Jeanie Bourke - Re: 616 Congress ST., B#2015-01687 plan review comments

Good Afternoon Thomas and Buell,

I have completed the review of the above project for building code and have the following comments as noted on the attached file(s).

(A) Building Section looking West

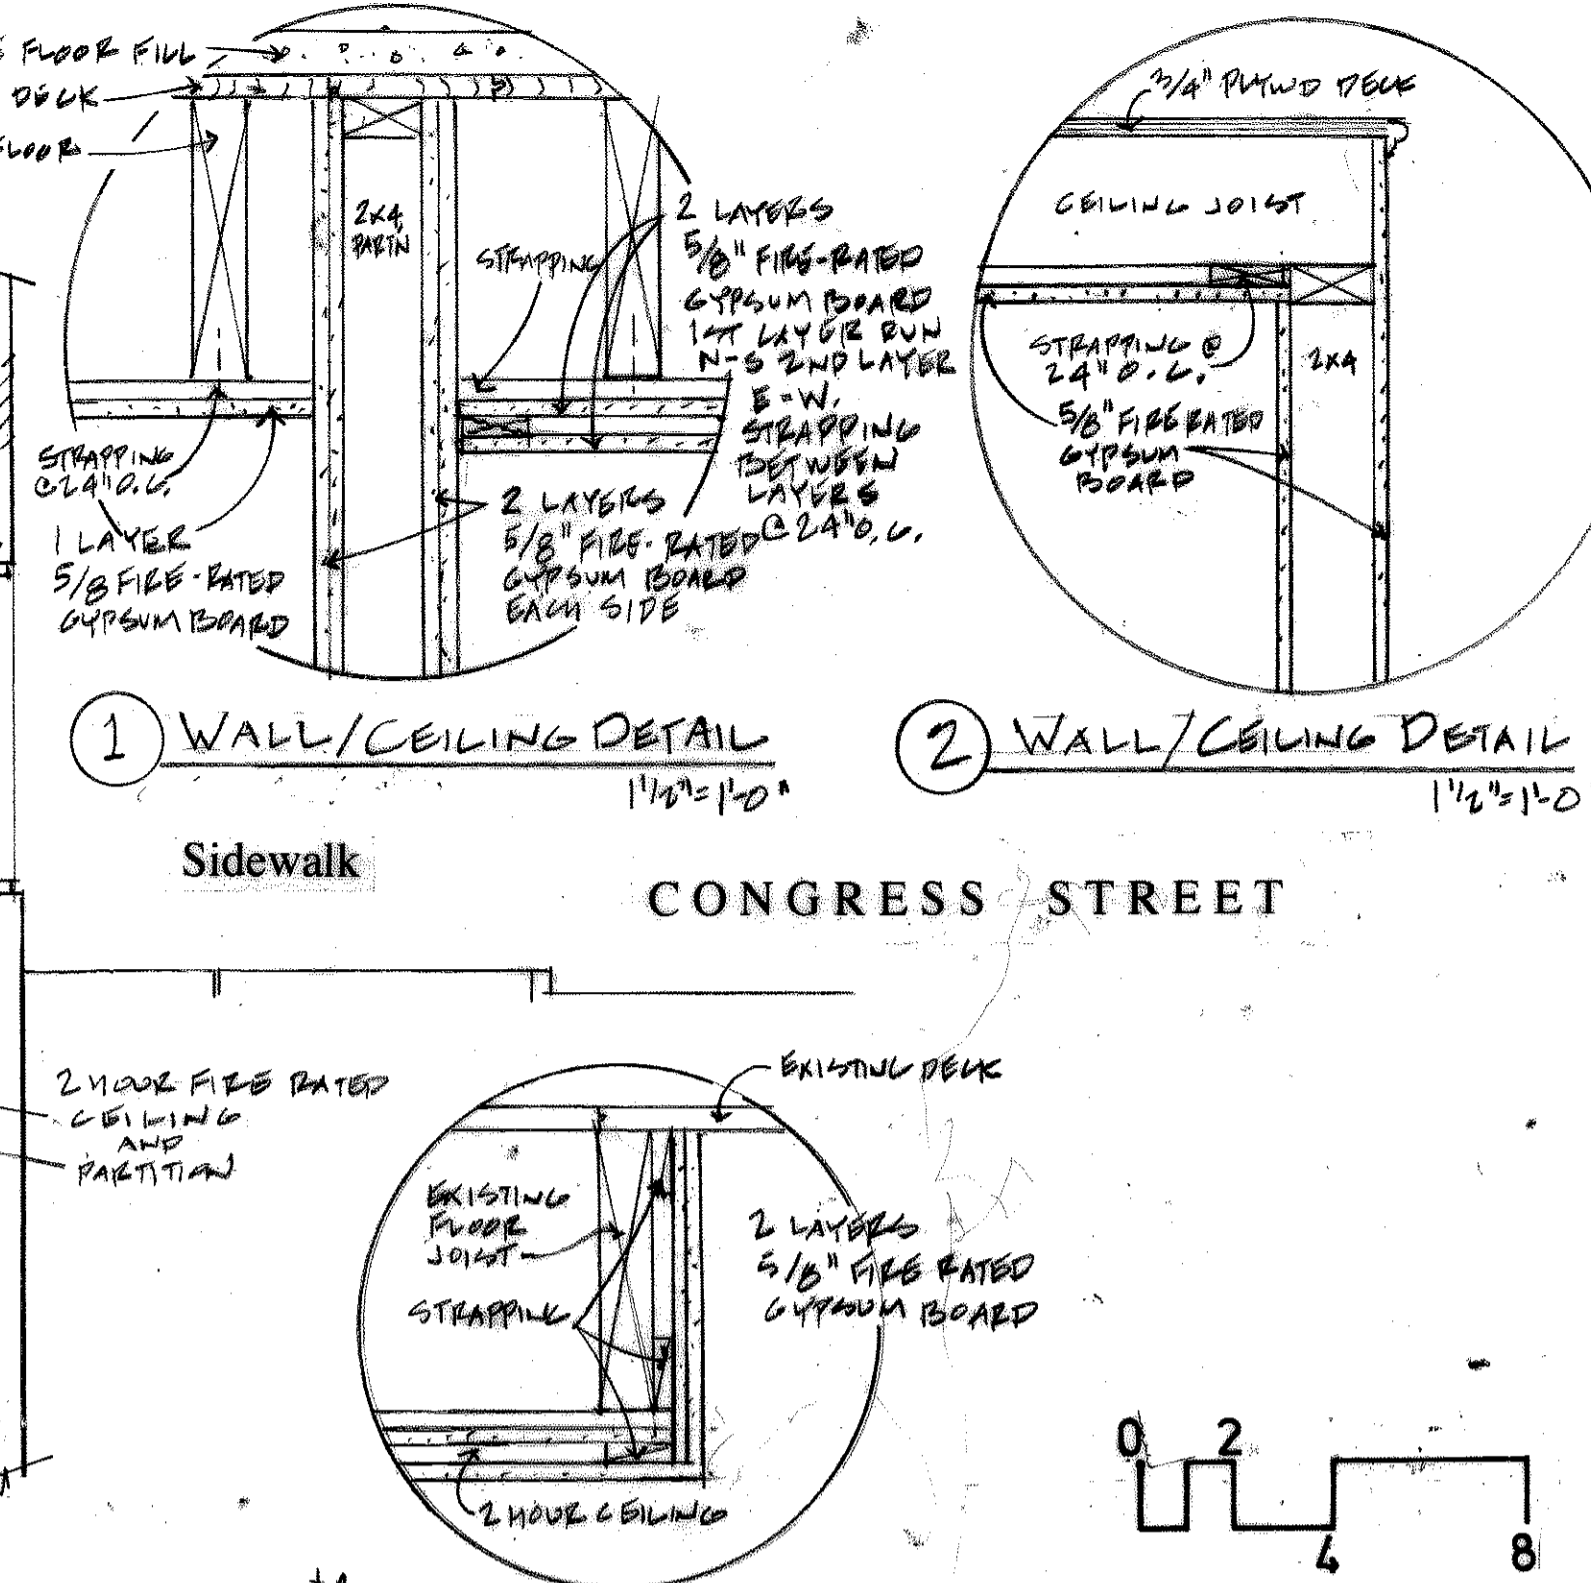
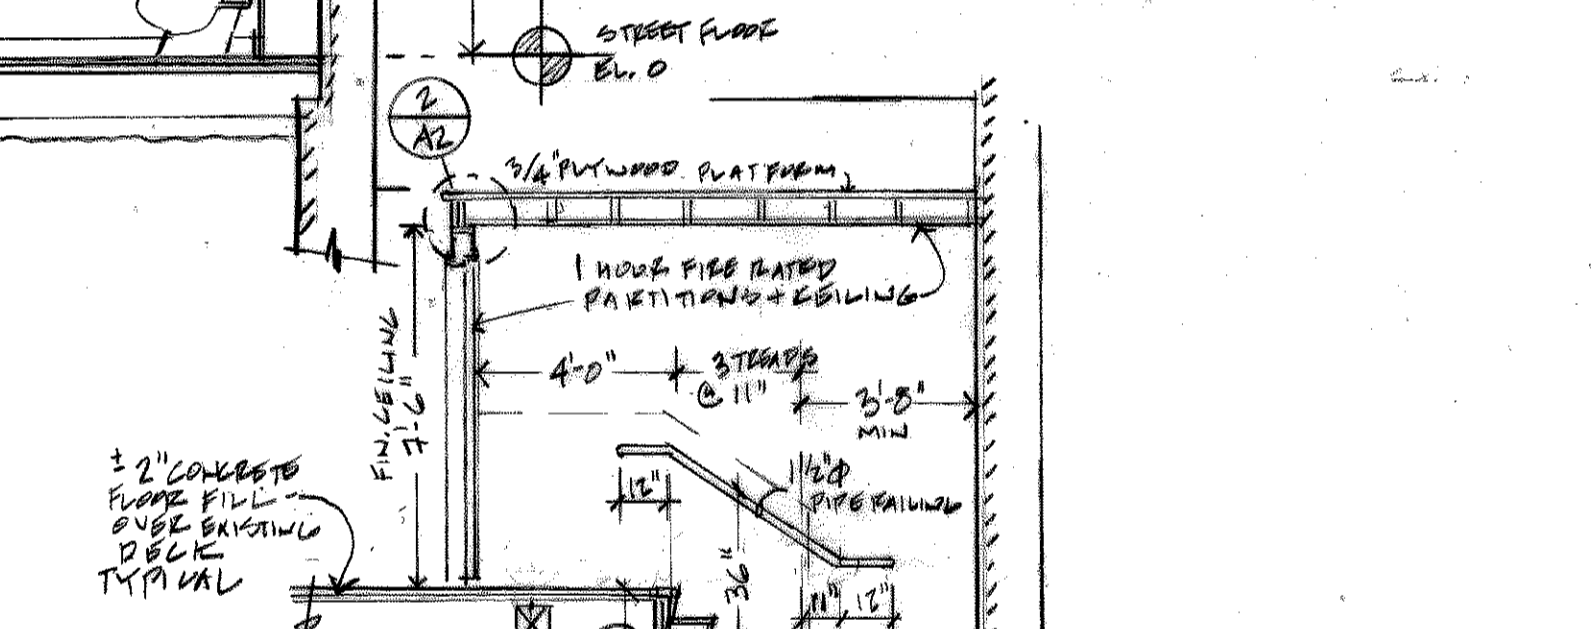
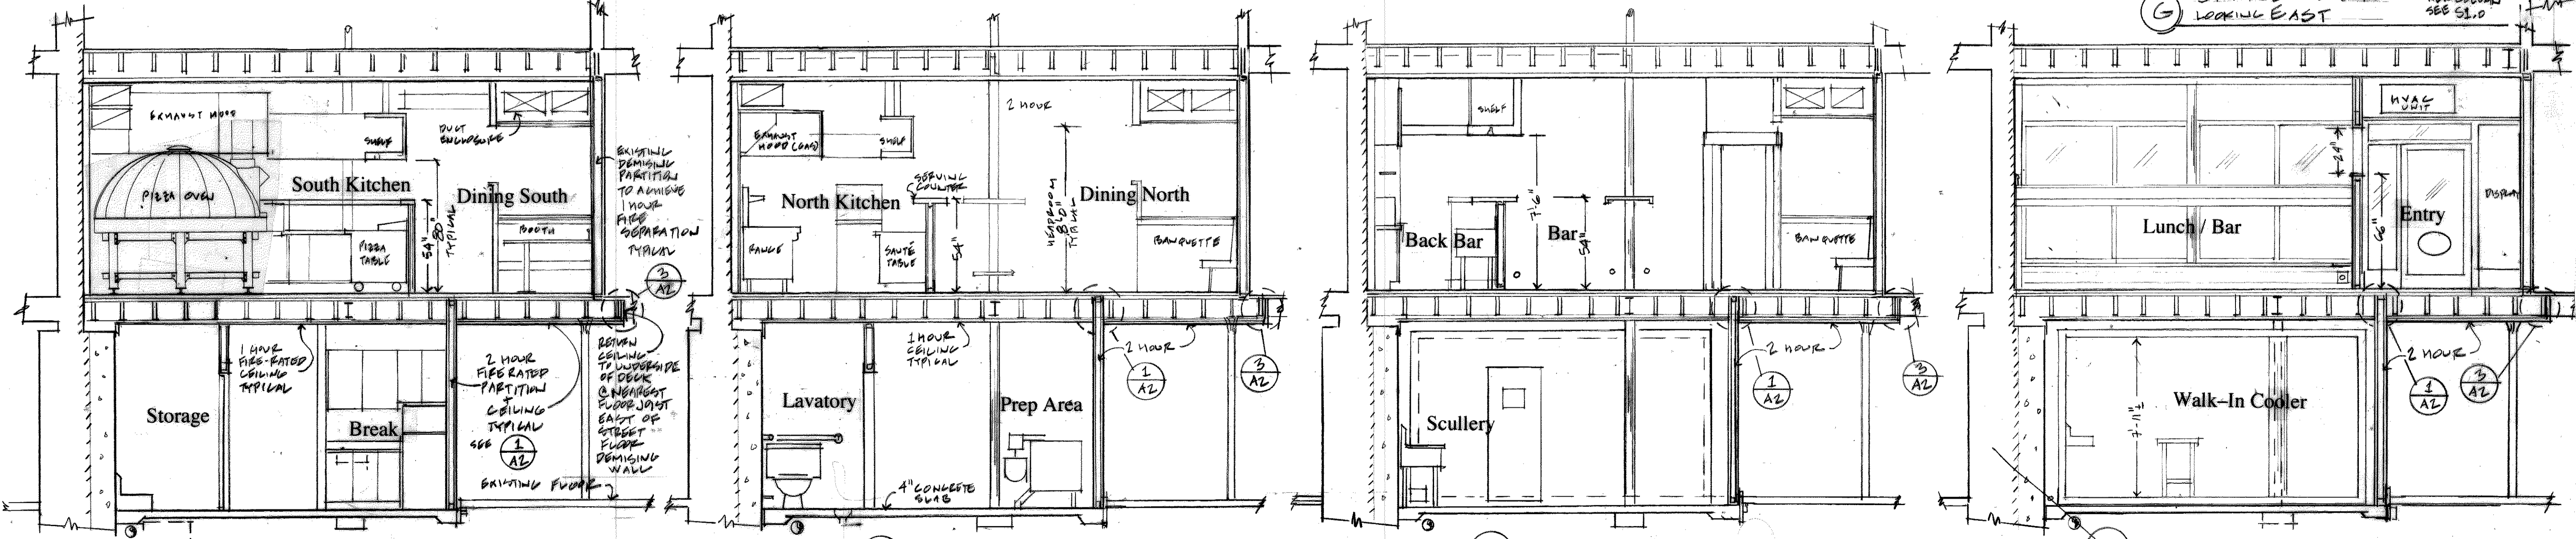
- I will forward manufacturer specifications in a separate email. We did hire a structural engineer to address the issue of the weight load. This is not a built in masonry oven but rather a manufactured "turnkey" oven sitting on a fabricated metal frame. Buell should be able to follow up with additional engineering information if it's needed regarding this.
